DEVELOPMENT CONSENT ORDER EN010012 : THE SIZEWELL C PROJECT

SUBMITTED WRITTEN RESPONSE TO ADDITIONAL SUBMISSIONS AS 013, AS 261 and AS 266.

Sylvia Ballard
BHS and Cycling UK Member

DRAWING TITLE:
 CONSTRUCTION PHASE

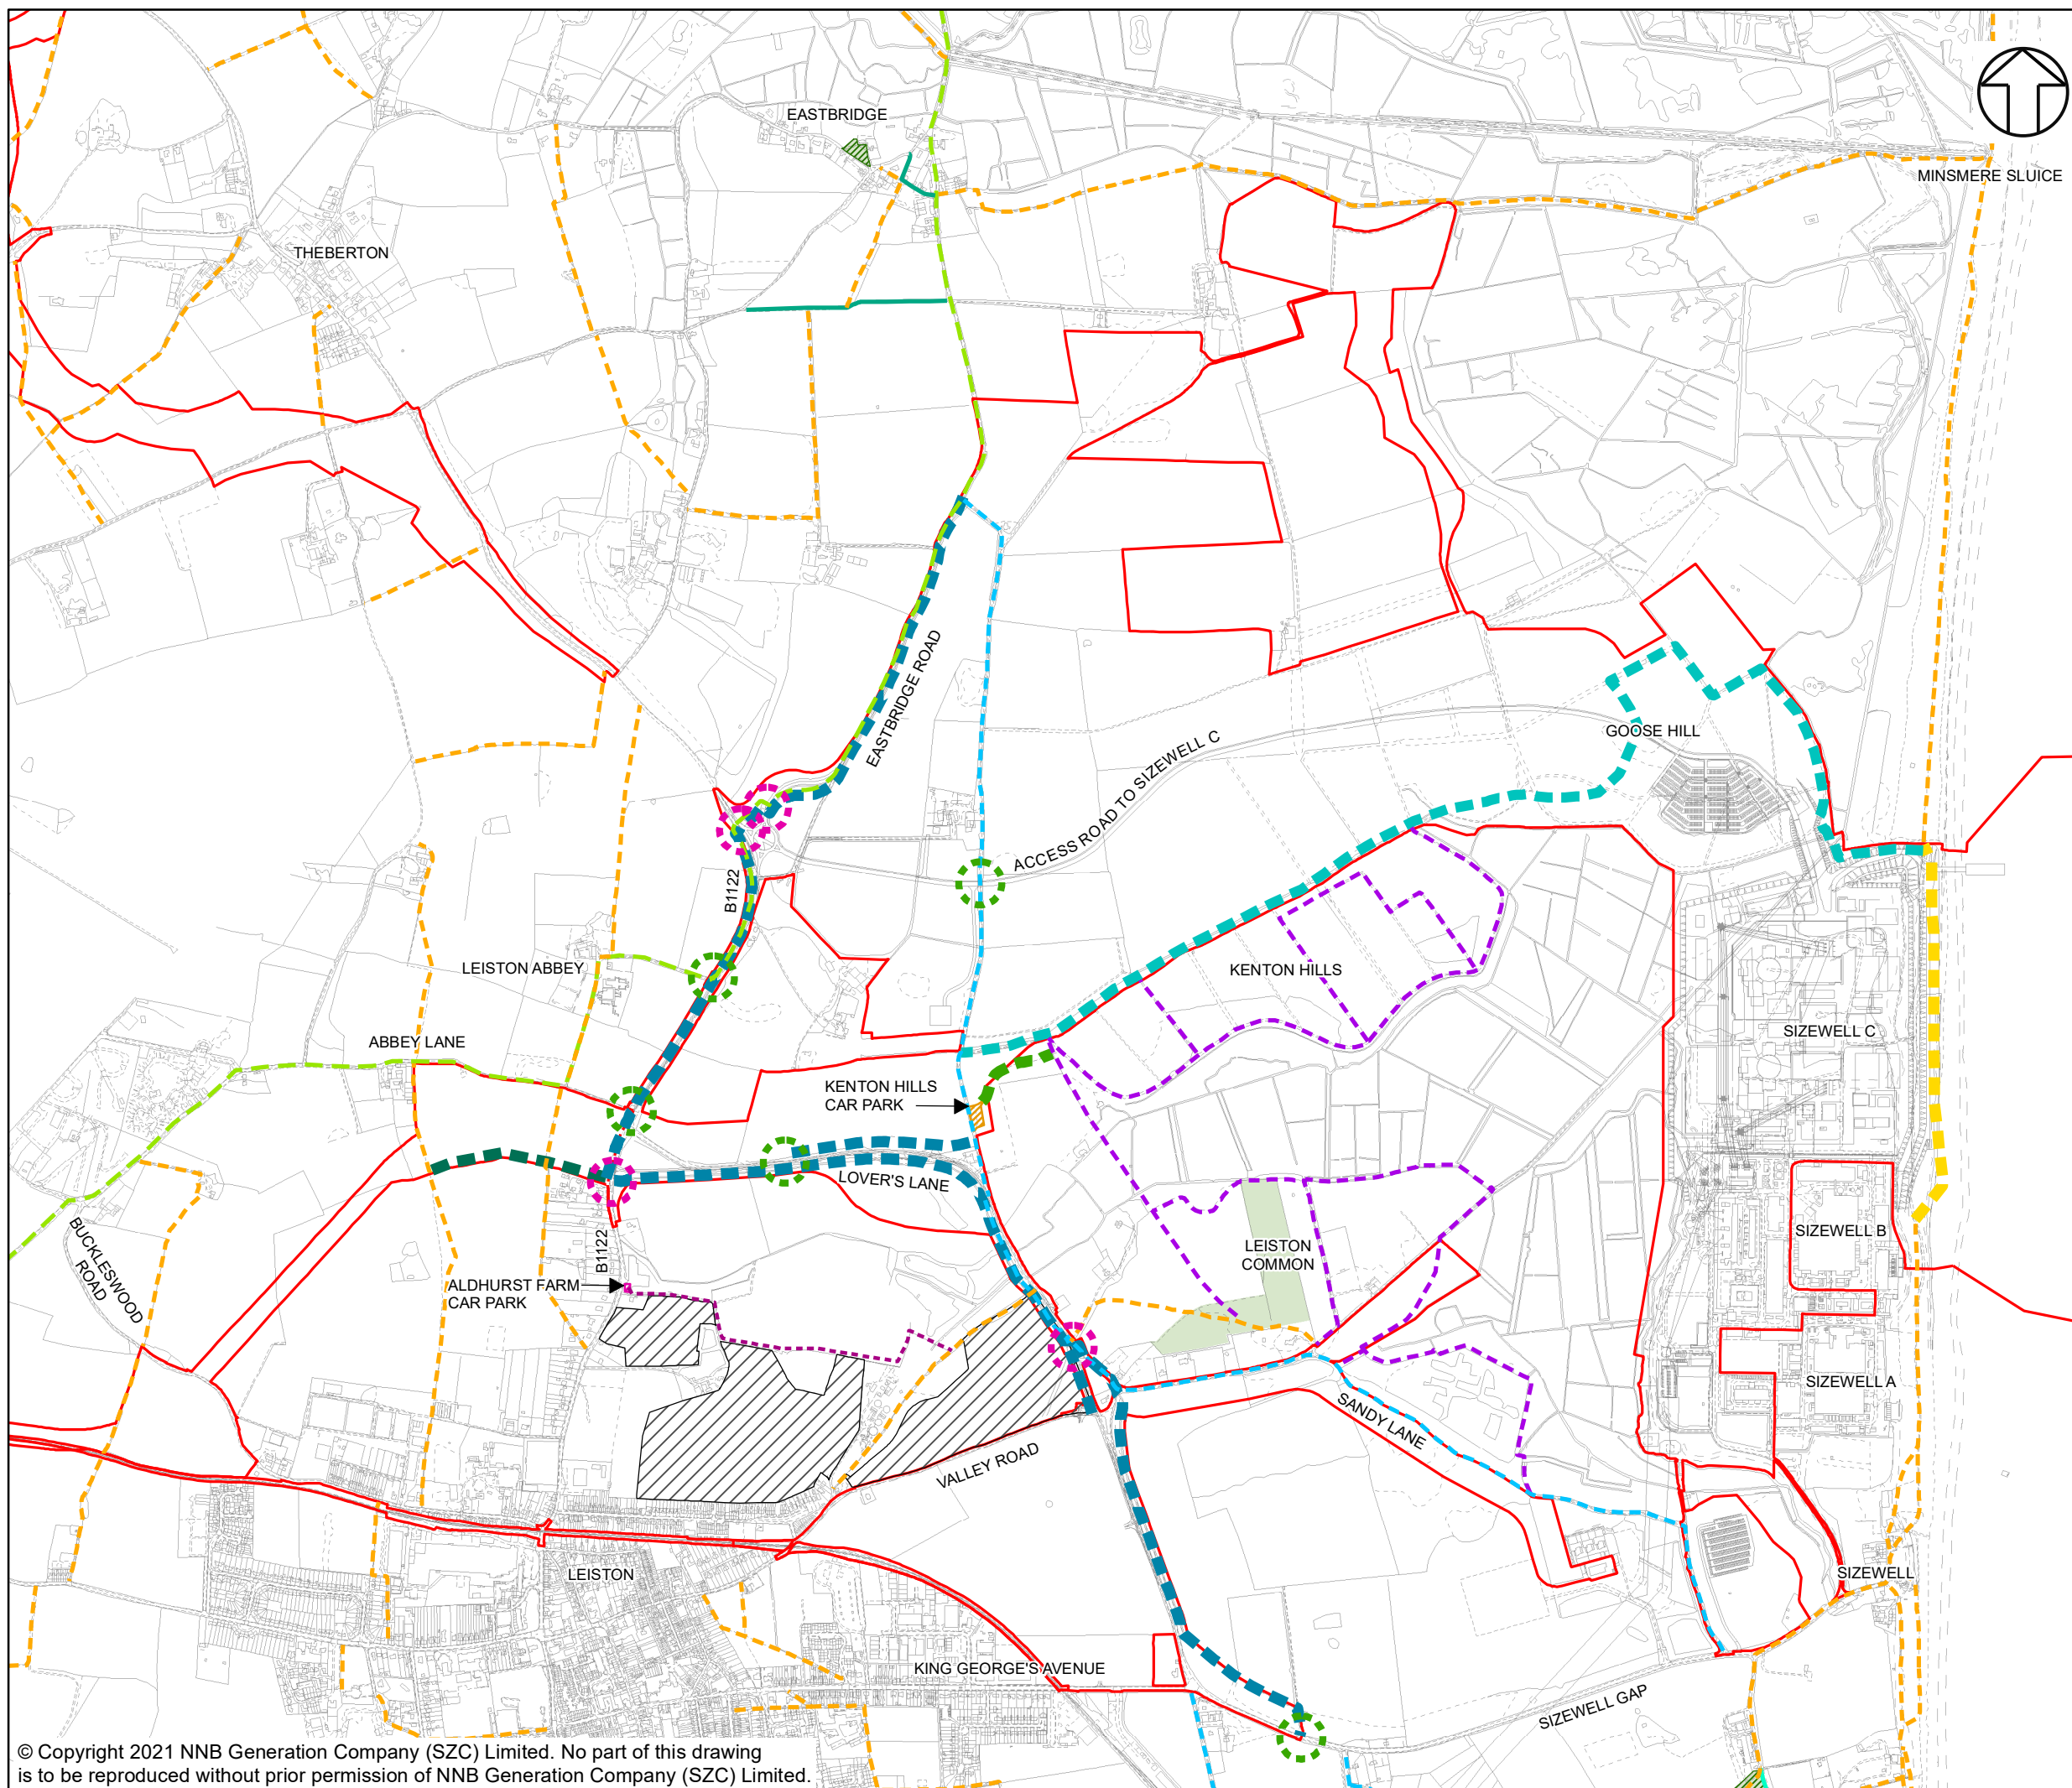
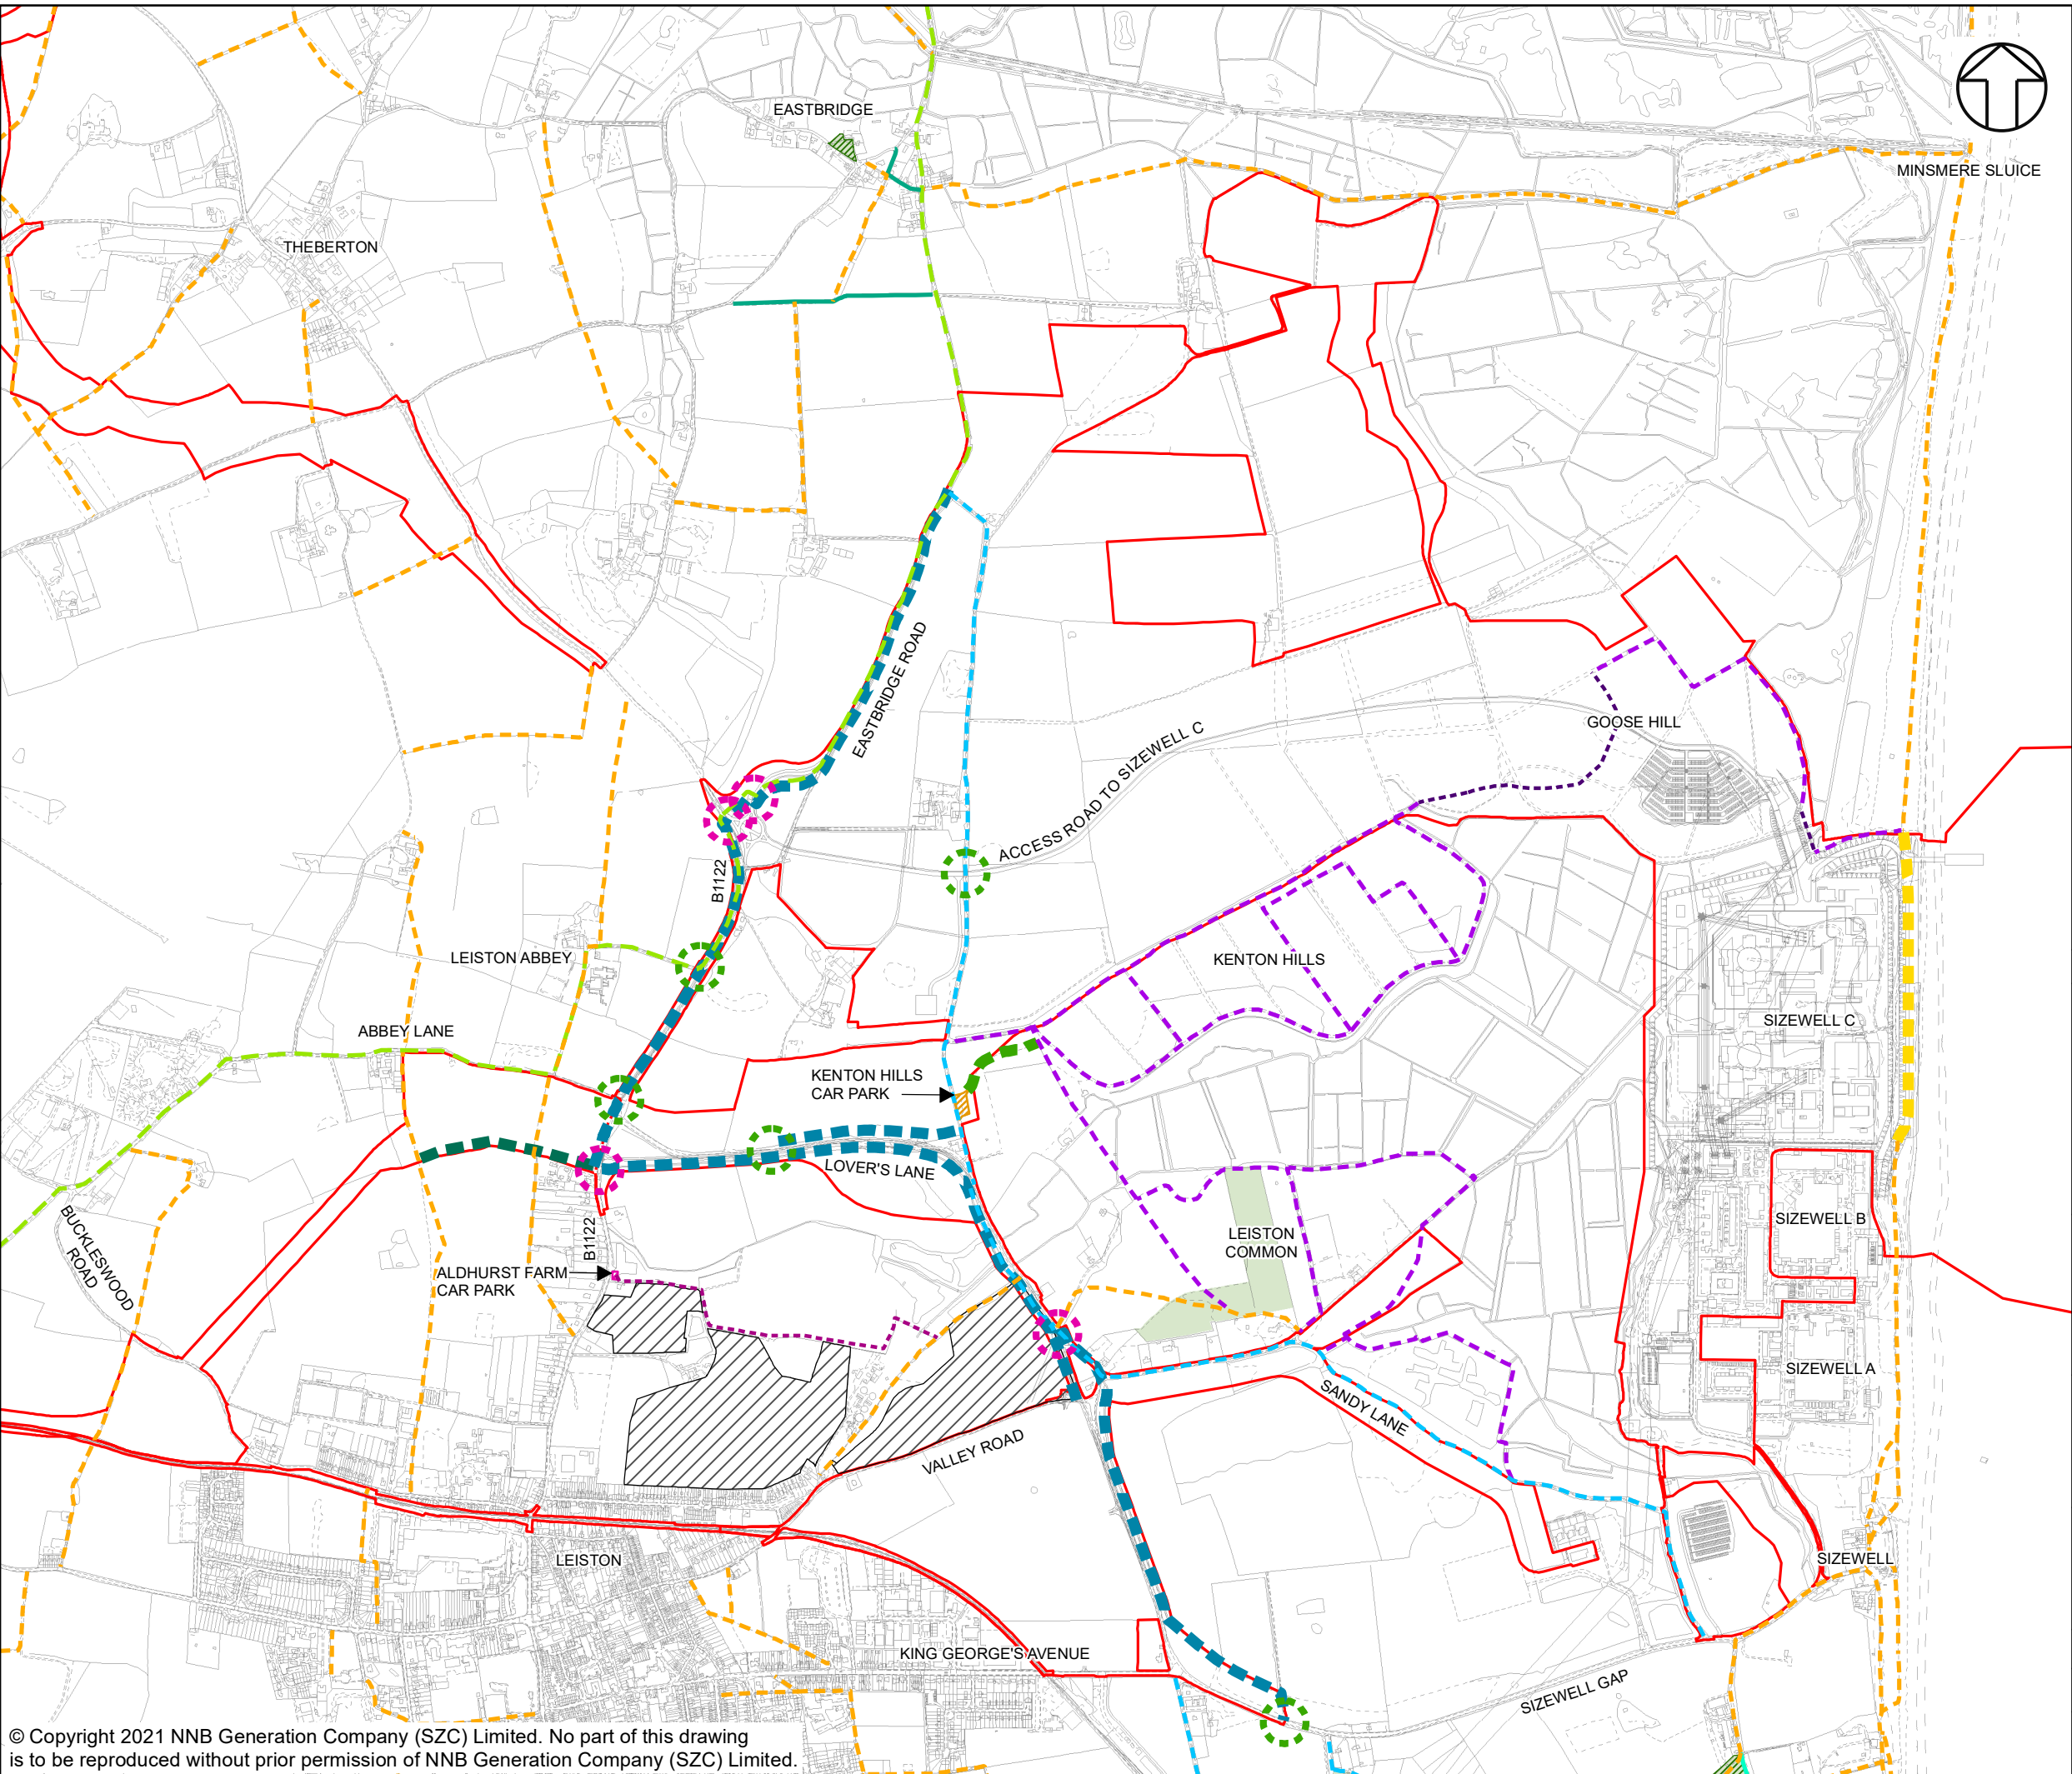
The proposed diverted route for **BR19**, which would also include the temporary diversions of the Suffolk Coast Path and the Sandlings Walk, was identified at an early stage in [\(APP 270\) Environmental Statement Volume 2 Chapter 15 Amenity and Recreation](#) and shown in **Appendix 15I Figure 15I.2.** (page 118)

1.2.16. The new off-road bridleway would be constructed prior to the closure of the Coast Path and temporary diversion of bridleway 19 and closure of bridleway E-363/013/0.

However, the only possible alternative route for **BR19** will not be available until the end of the initial construction stage. As **BR19** is located within the construction site, the route cannot safely remain open to the public during the construction of the alternative route.
